12900 Murphy Road, Major Kennel, PPR-22-20

Please accept the following comments from El Paso County Public Health regarding the project referenced above:

Footprint of all existing and proposed buildings and the setback distances from each existing and proposed structure to the property lines. No sidewalks.

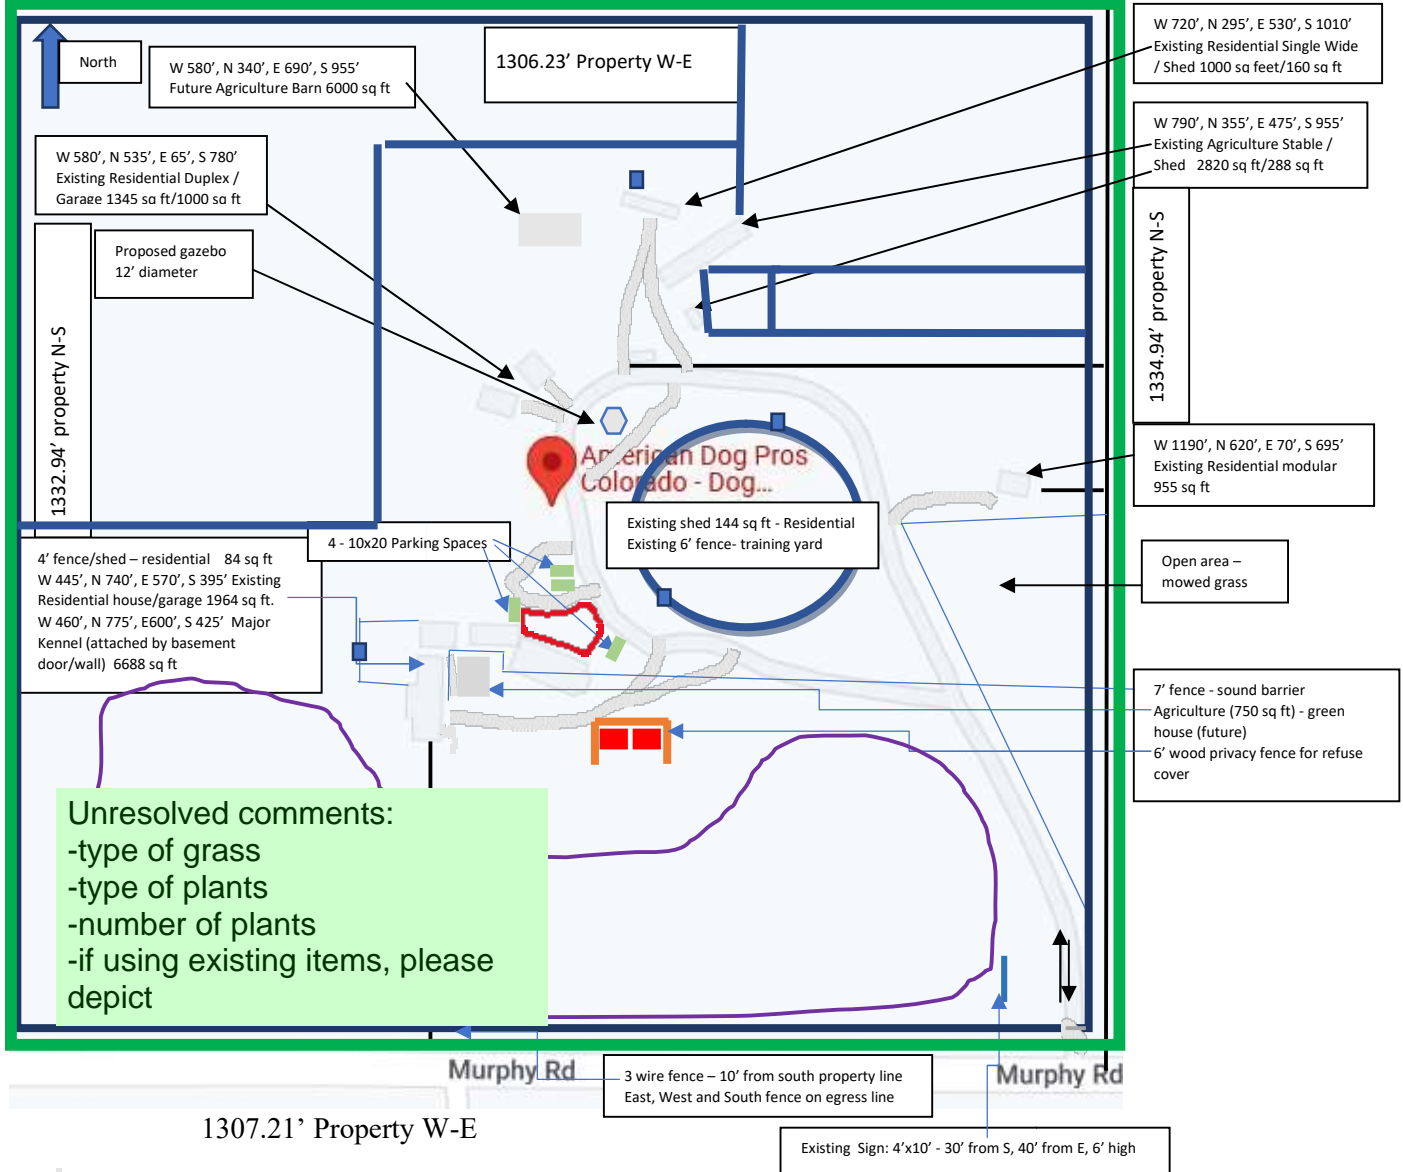
- A record of an approved, permitted on-site wastewater treatment system (OWTS) for this property indicates the OWTS was installed and approved for a 4-bedroom residence in 1976 and is located off the south end of the residence. The OWTS component locations are on file at El Paso County Public Health and accessible through the El Paso County Assessor's Office website property search page. Please make sure the components of the OWTS are protected from vehicular traffic and other means of compaction.
- El Paso County Public Health recommends storing animal food in impervious containers with lids to minimize rodents and insects.
- Animal waste should be managed properly to help control odors and minimize flies and other insects.
